From: Joanne Lewis <Joanne.Lewis@arun.gov.uk>
Sent: 19 January 2022 14:54
To: Planning.Responses <Planning.Responses@arun.gov.uk>
Subject: RE: Planning Consultation on: AL/141/21/RES

Application No: AL/141/21/RES
Registered: 20th December 2021
Site Address: Land North of Lee's Yard Lidsey Road Woodgate PO20 3SU
Grid Reference: 493870 104003
Description of Works: Approval of reserved matters following outline planning permission AL/21/20/OUT for the approval of the appearance, layout, scale and landscaping for 5 No 4-bed dwellings, 14 No 3-bed dwellings & 19 No 2-bed dwellings. This site is in CIL Zone 3 and is CIL Liable as new dwellings.

Drawing Name Landscape Strategy

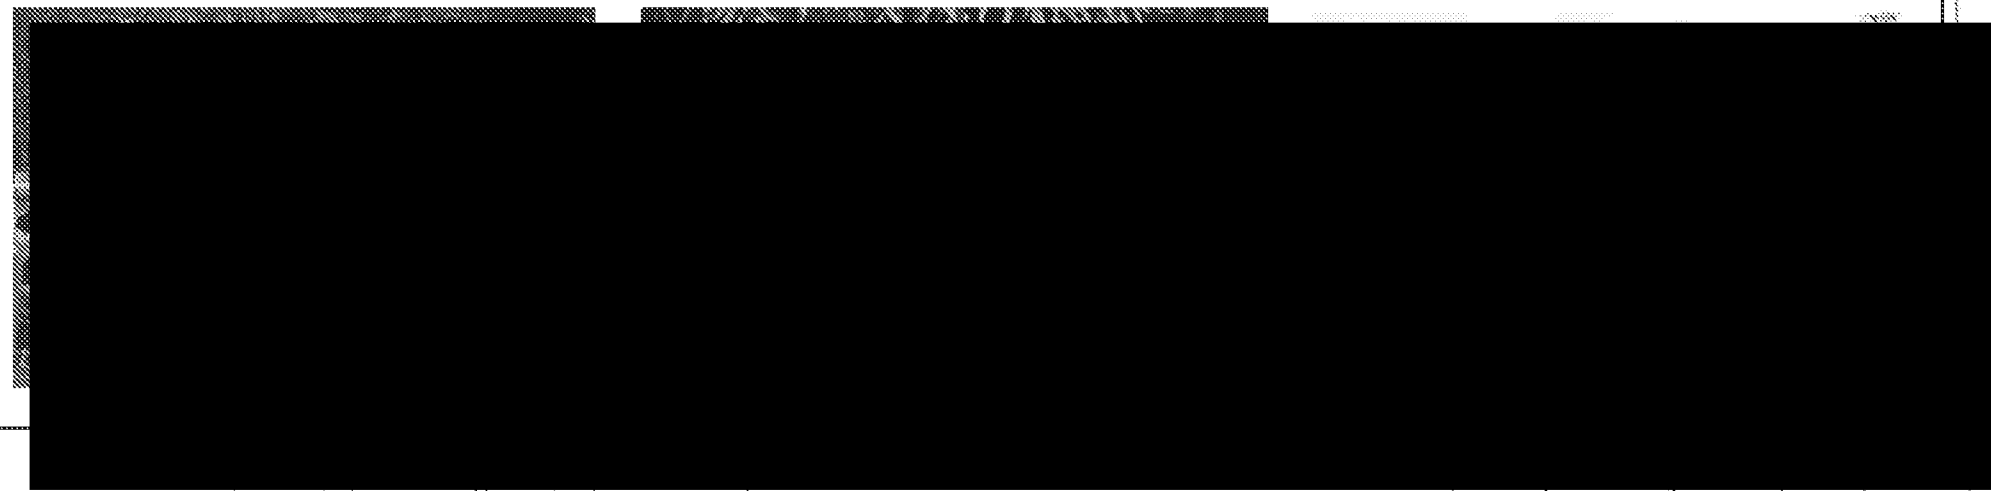
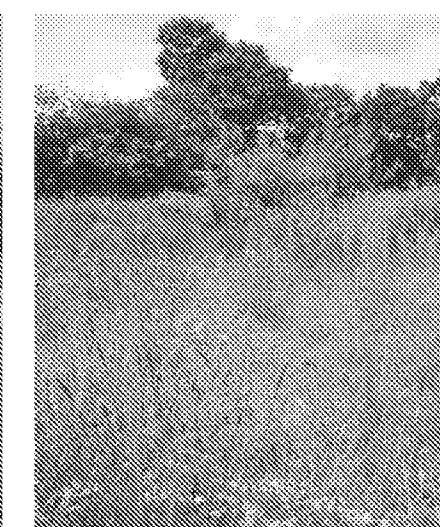
Please could it be clarified what FWPS is on the layout plan, if this is some form of pumping station the following condition should be included;

Noise from the pumping station shall not exceed 45dB LAeq (15mins) with no tonal components evident at the boundary of the nearest noise sensitive property. When assessed by a competent acoustic engineer, the Vibration Dose Value (VDV) shall not exceed the applicable 'low probability of adverse comment' level for the test environment in question (i.e. residential buildings, offices, workshops) contained within BS 6472-1:2008 (Guide to evaluation of human exposure to vibration in buildings – Part 1: Vibration sources other than blasting) inside the nearest property. A test or prediction of the noise levels and a test or estimation of the expected vibration environment to demonstrate compliance with the levels shall be undertaken within 3 months of the development being implemented and submitted to the local planning authority for approval.
